Ref :LOCAL ROAD L3412

SECTION 177AE – IDA

Belview Infrastructure

Development, Belview Slieverue

Title: **Proposed Access Road Layout Sheet 1 of 2**

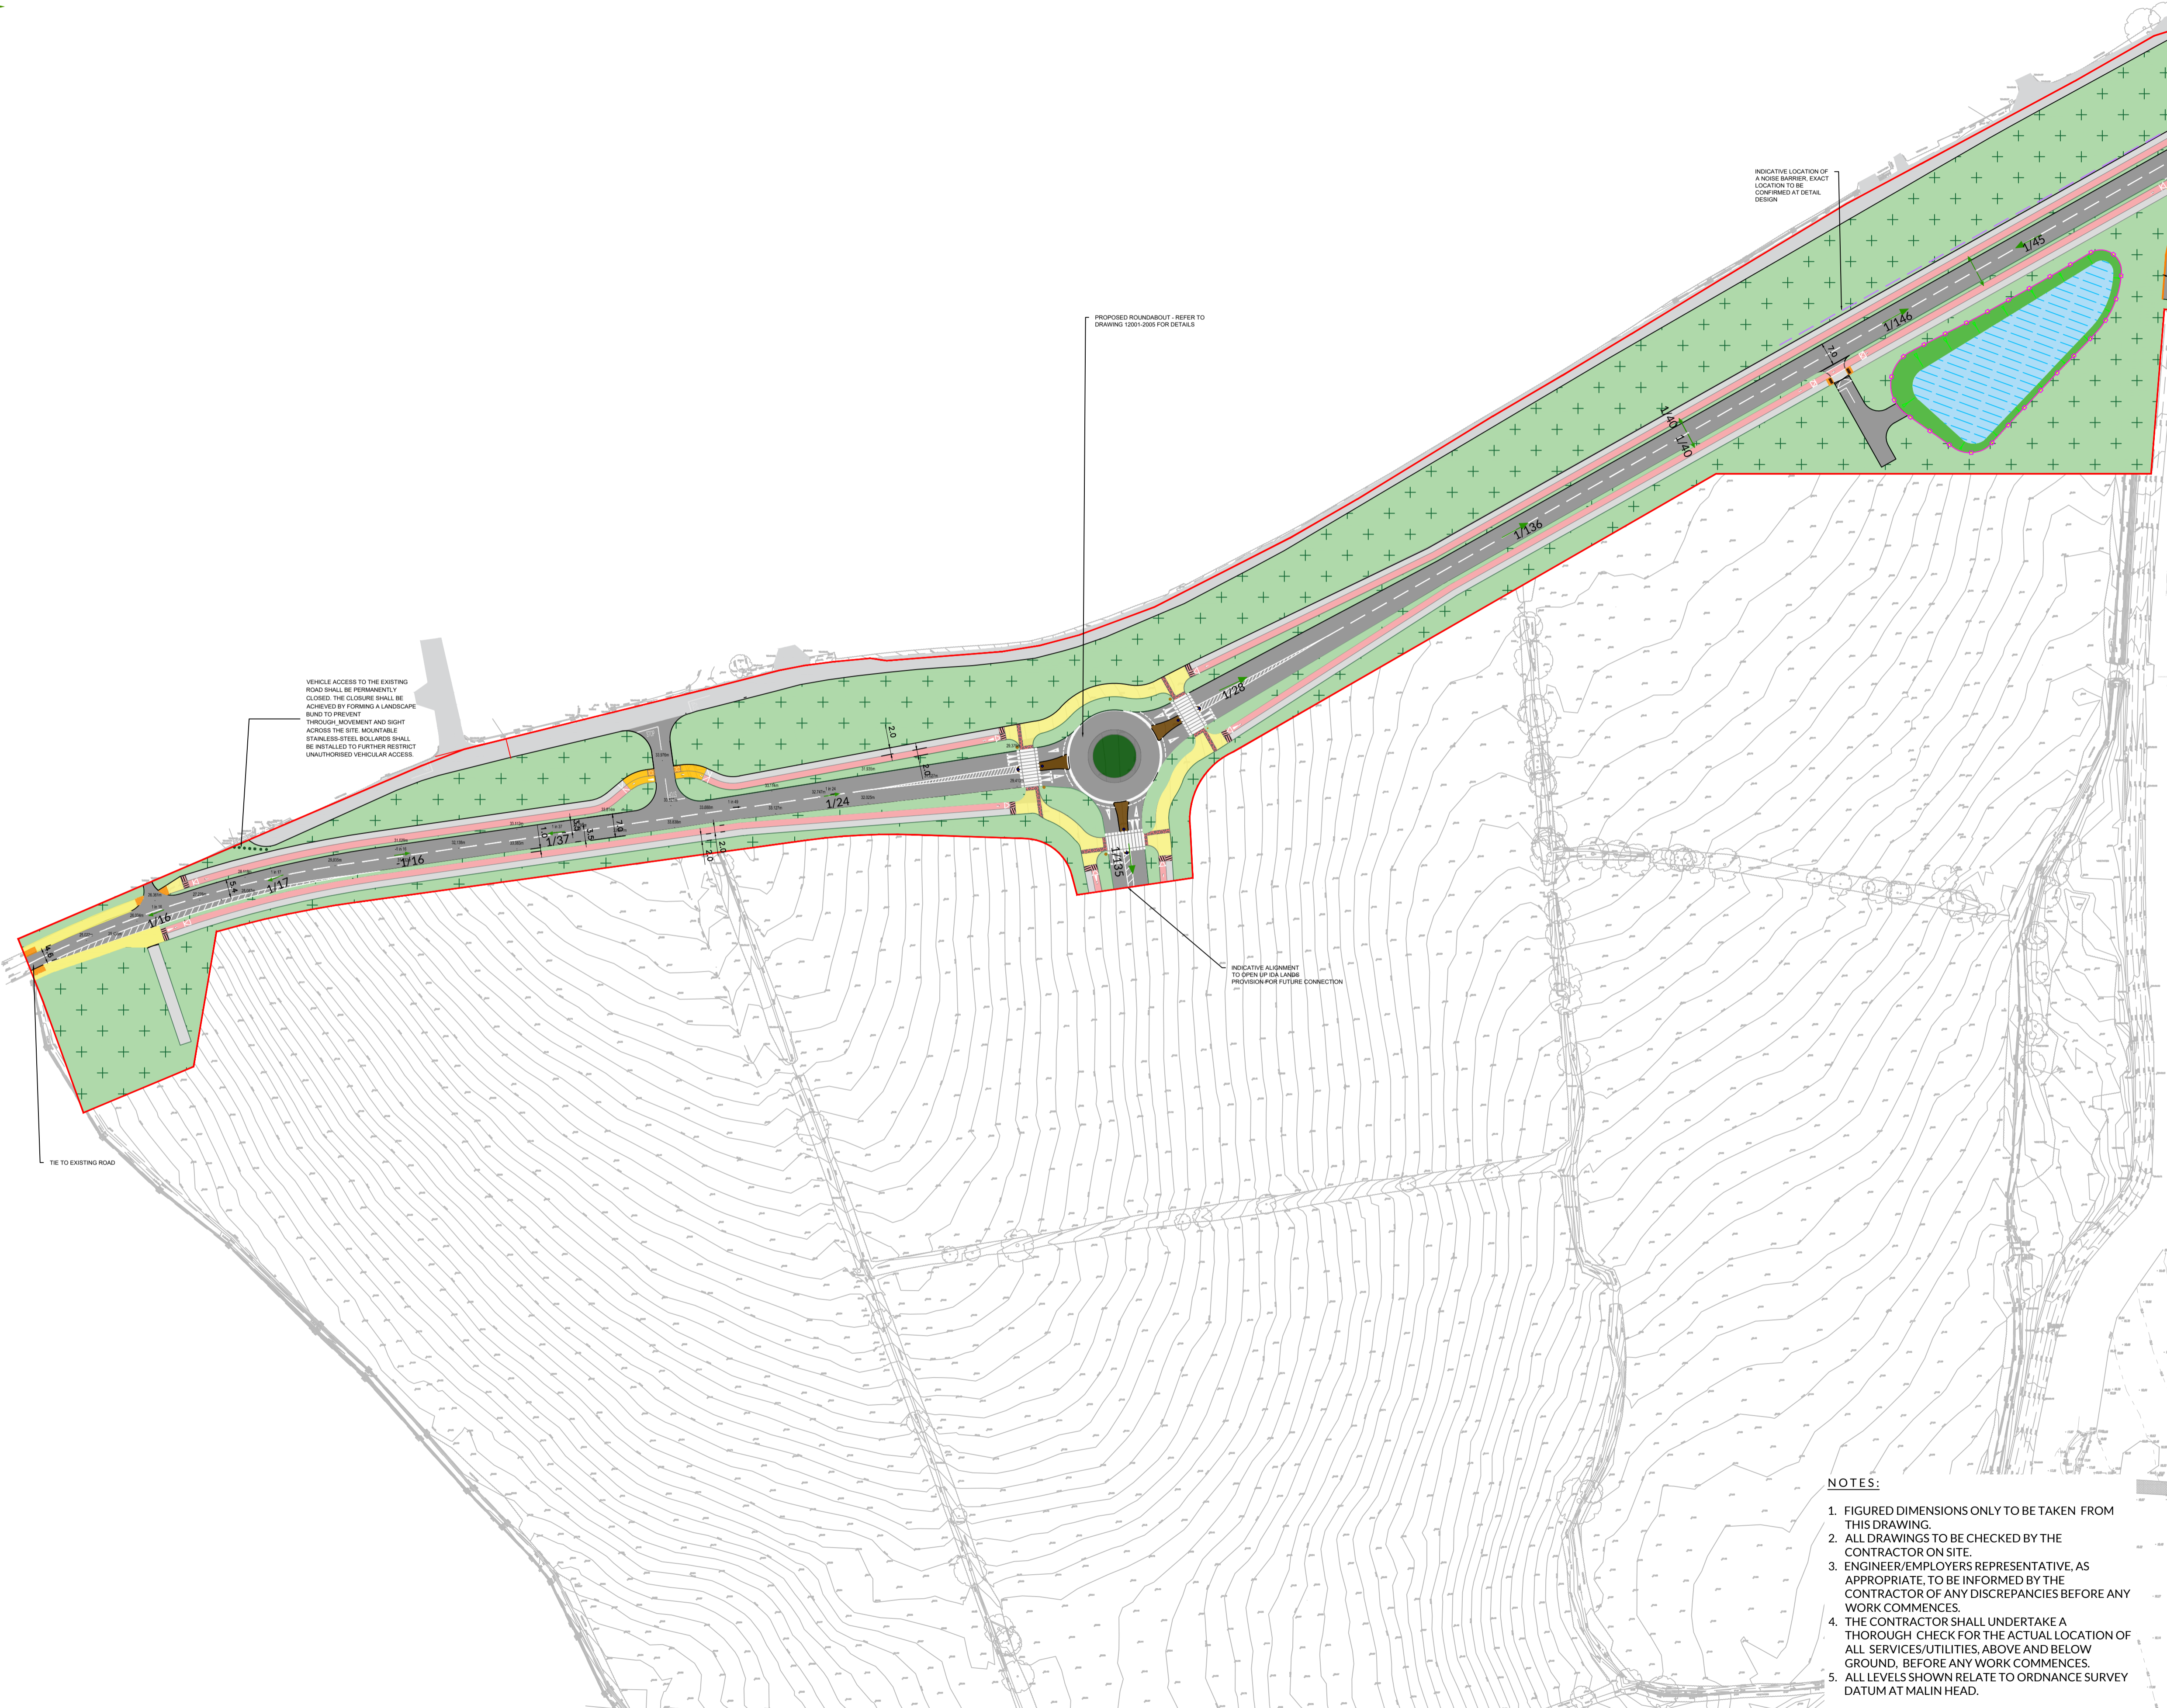
I wish to make a submission objecting to the above Planning of the new road. There was no sweep way done down my road to allow any big vehicles access to my property safely.

The installing of the bollards being placed outside my property which will be ending in a **cul-de-sac** will create significant access and safety concerns.

The bollards effectively will cut off direct access to my neighbour and leave insufficient space for large vehicles to manoeuvre safely in your proposed outside my house.

Of particular concern is emergency access, the restricted turning and reversing space could prevent or delay ambulances, fire service vehicles or other emergencies responders from reaching my property quickly when every minute is critical. In addition essential service vehicles including home heating oil tankers, delivery Lorries, refuse collection vehicles

, and other large trucks, do not have adequate room to reverse or turn safely because of the bollards.
